SUBJECT: BRES2501-0019
BUILDING RESIDENTIAL

Here are the results of all Inspections located at **261 MABRY RD:**

LANDSCAPE PLAN

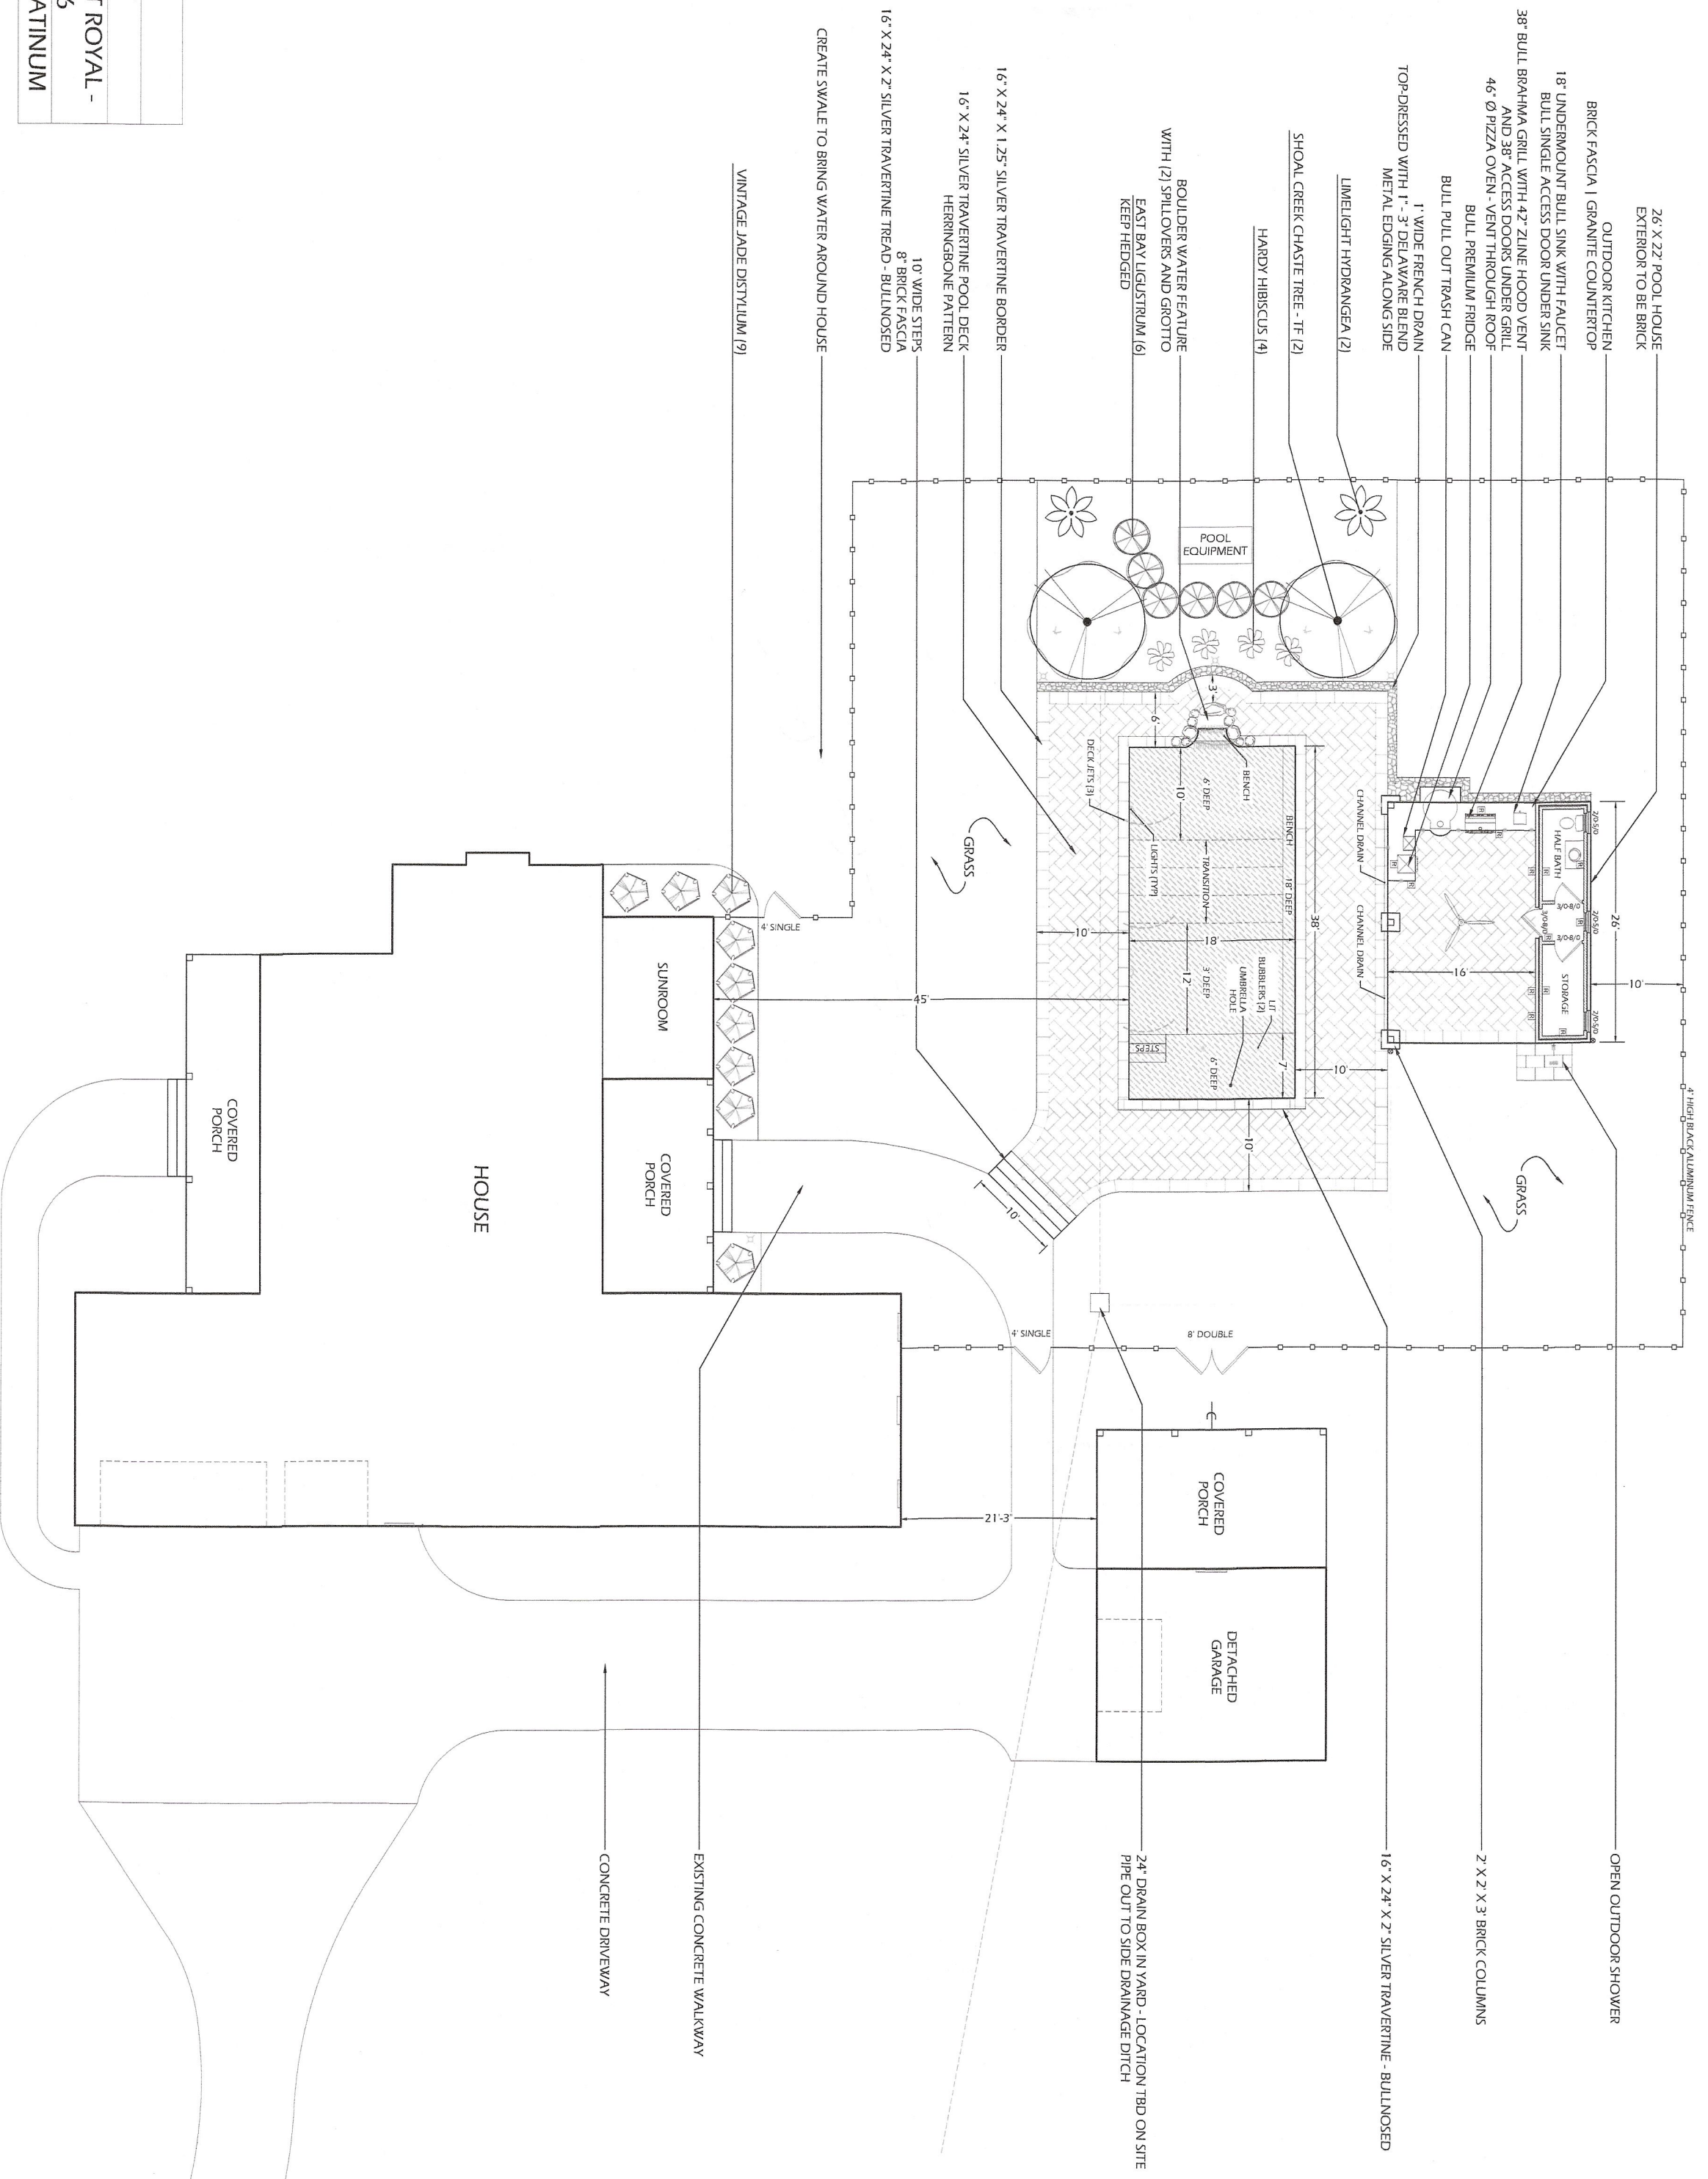
Inspection Type: FINAL**
Scheduled Date/Time: 9/26/2025
Completed Date/Time: 9/26/2025
Inspector: Brad Sutton
Result: DISAPPROVED
Remarks:
Notes: 1. Could not locate an accessible bonding tee for water bond.2. Main bonding wire from pool is tied only to controller. Bond from motors are tied to heater, but the bonds are not tied together. All bonding wires shall be bonded together.3. Provide code compliant UL 2017 alarms on all doors leading into pool area from house as well as pool house.4. Need a handrail at one side of steps to pool. 4 risers.

Inspection Type: FINAL**
Scheduled Date/Time: 10/21/2025
Completed Date/Time: 10/21/2025
Inspector: Kory S Denny
Result: DISAPPROVED
Remarks:
Notes: Need to verify an accessible water bond and door alarms from dwelling to pool area
